DECISION DELEGATED TO HEAD OF PLANNING
--

Application No:	H23-1132-23	Applicant:	Mr D Ford
Proposal:	Conversion of three agricultural barns into four residential dwellings involving the demolition of a fourth barn		
Location:	Carter'S Farm Oxcroft Bank Shepeau Stow		
Terminal Date:	11th March 2024

Job Title Proposed Barn Conversions Carter's Farm, Oxcroft Bank, Shepeau Stow, Spalding, Lincs, PE12 0TY	Date December 2023	Drawn by GT Checked by GE
Drawing Title Planning Drawing Barns 2, 3 & 4	Job No. SE-2039 Dwg No. PP1100	Sheet Size A1 Revision

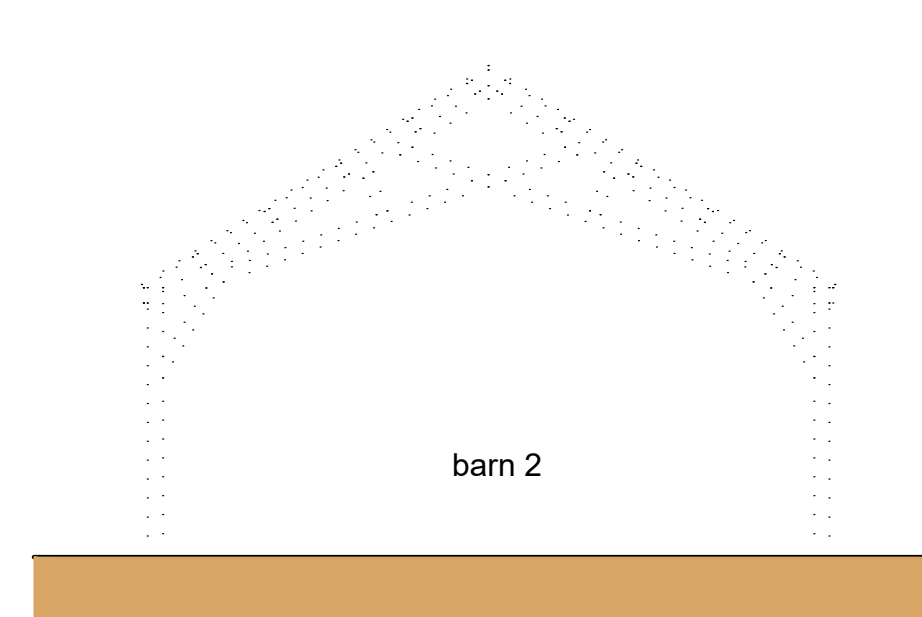
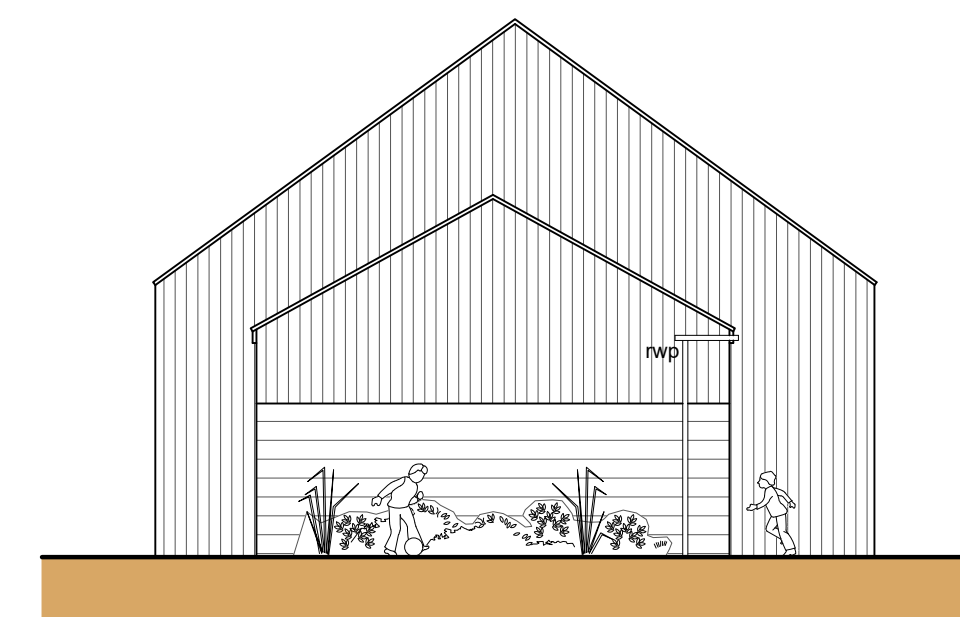
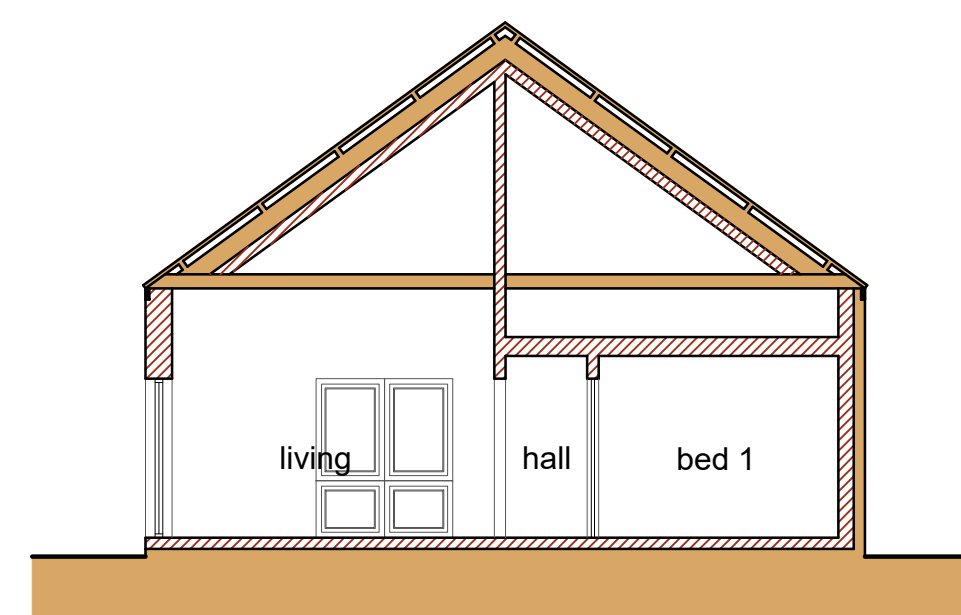
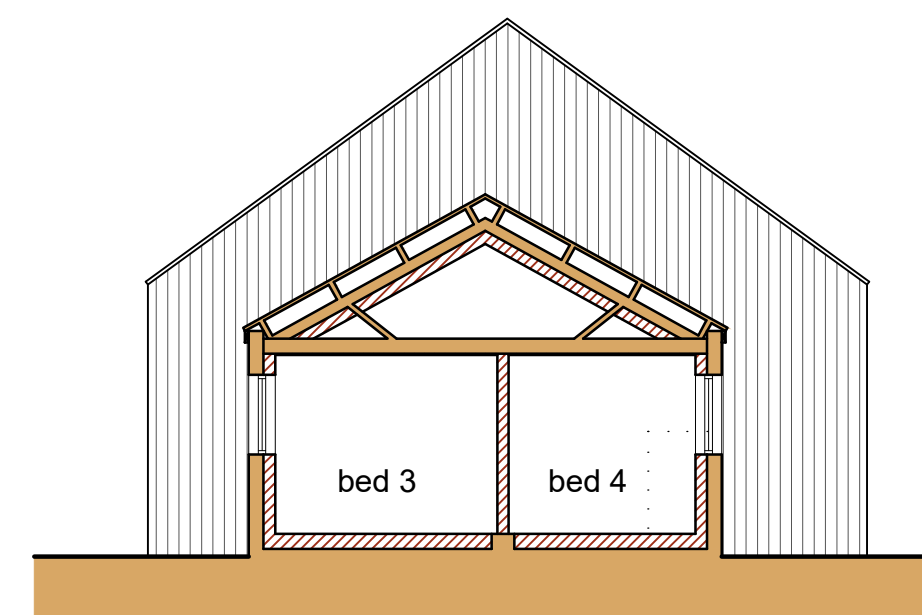
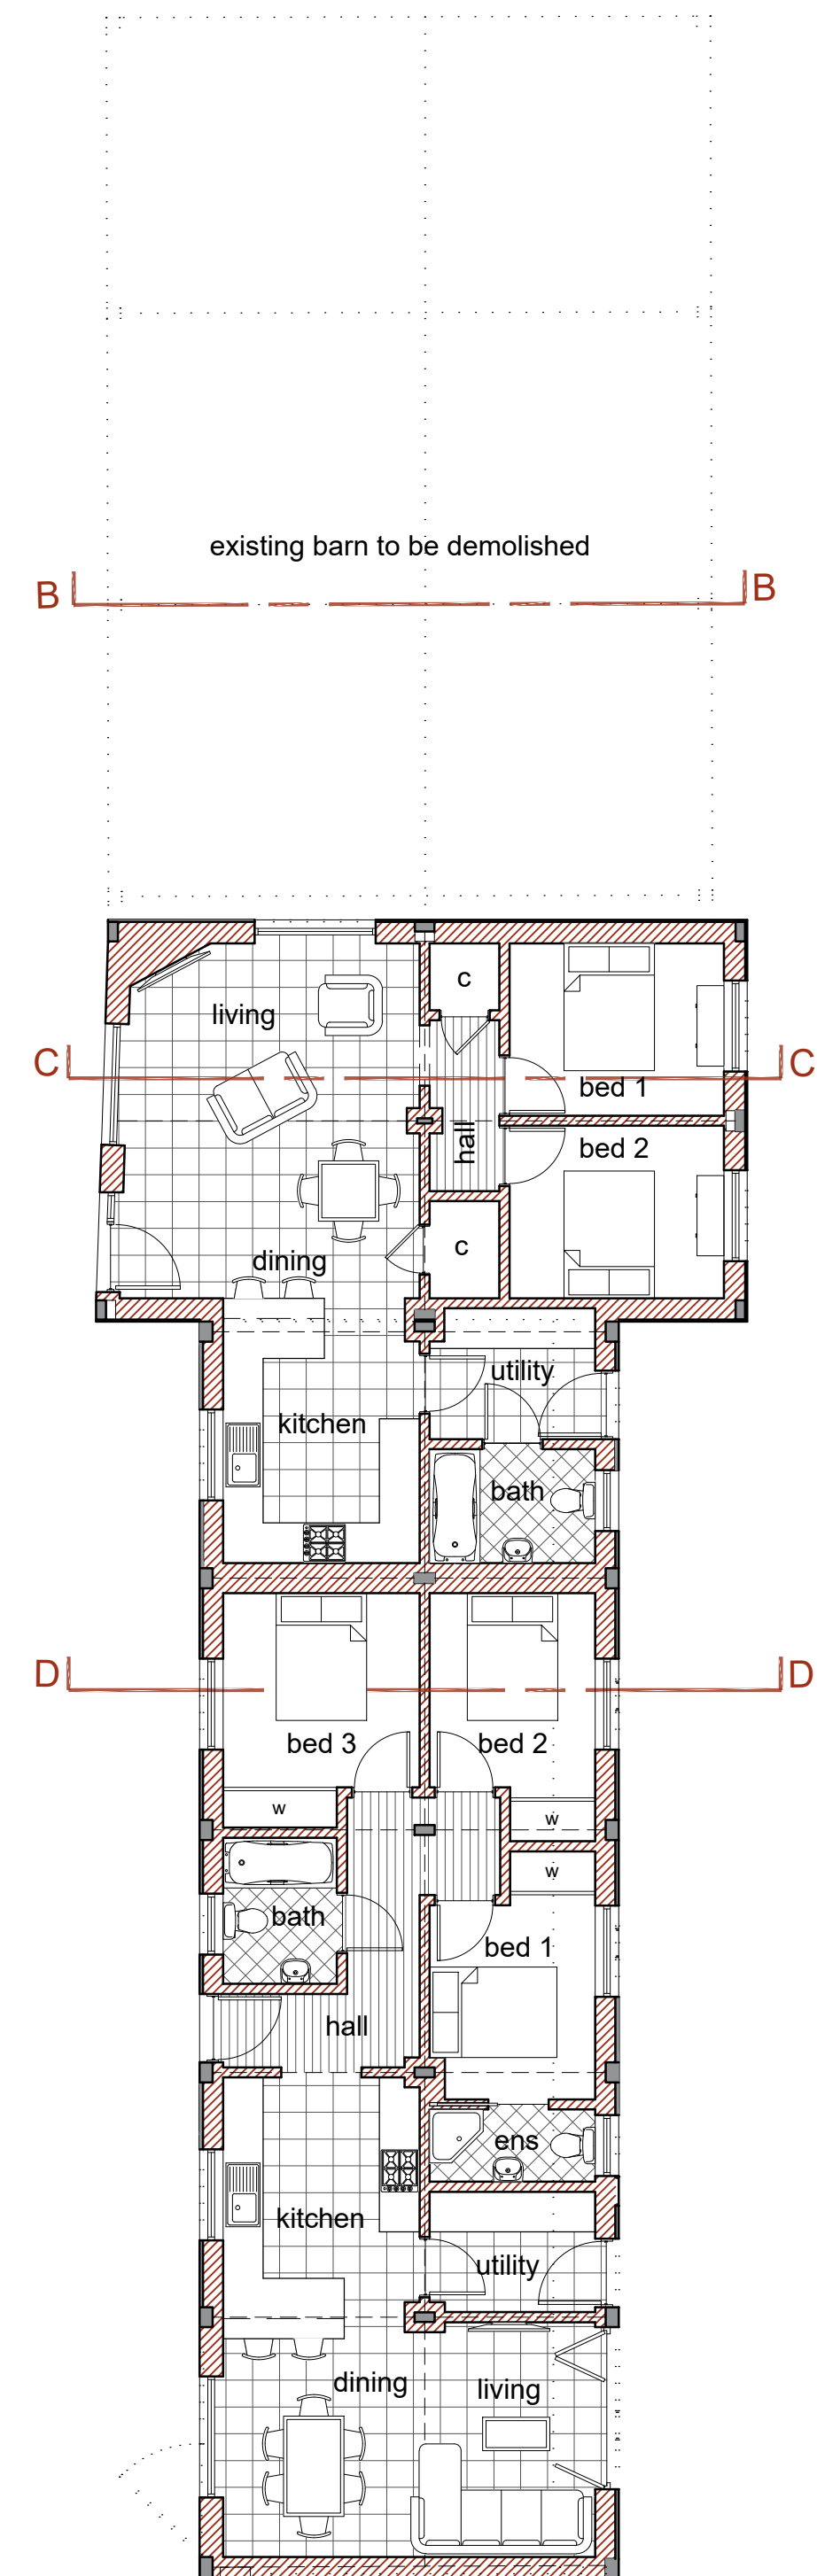
In this case, it is noted that the existing framework of barns 3 and 4 is predominantly timber. The structural report accompanying the application provides more specific details and indicates that the majority of the primary structural elements could be retained and "subsumed" into the residential conversion. This implies that the existing frame is inadequate for the proposed loads and that

significant additional structural elements would be required. The buildings are not therefore considered to be capable of being converted to residential use without building operations that would be so extensive as to go well beyond the scope of the operations permitted by Class Q, and would amount either to substantial rebuilding of the pre-existing structure or, in effect, the creation of a new building.

Also, Barns 3 and 4 especially are not considered to be capable of being converted to residential use without building operations that would be so extensive as to go well beyond the scope of the operations permitted by Class Q and would amount either to substantial rebuilding of the pre-existing structure or, in effect, the creation of a new building.
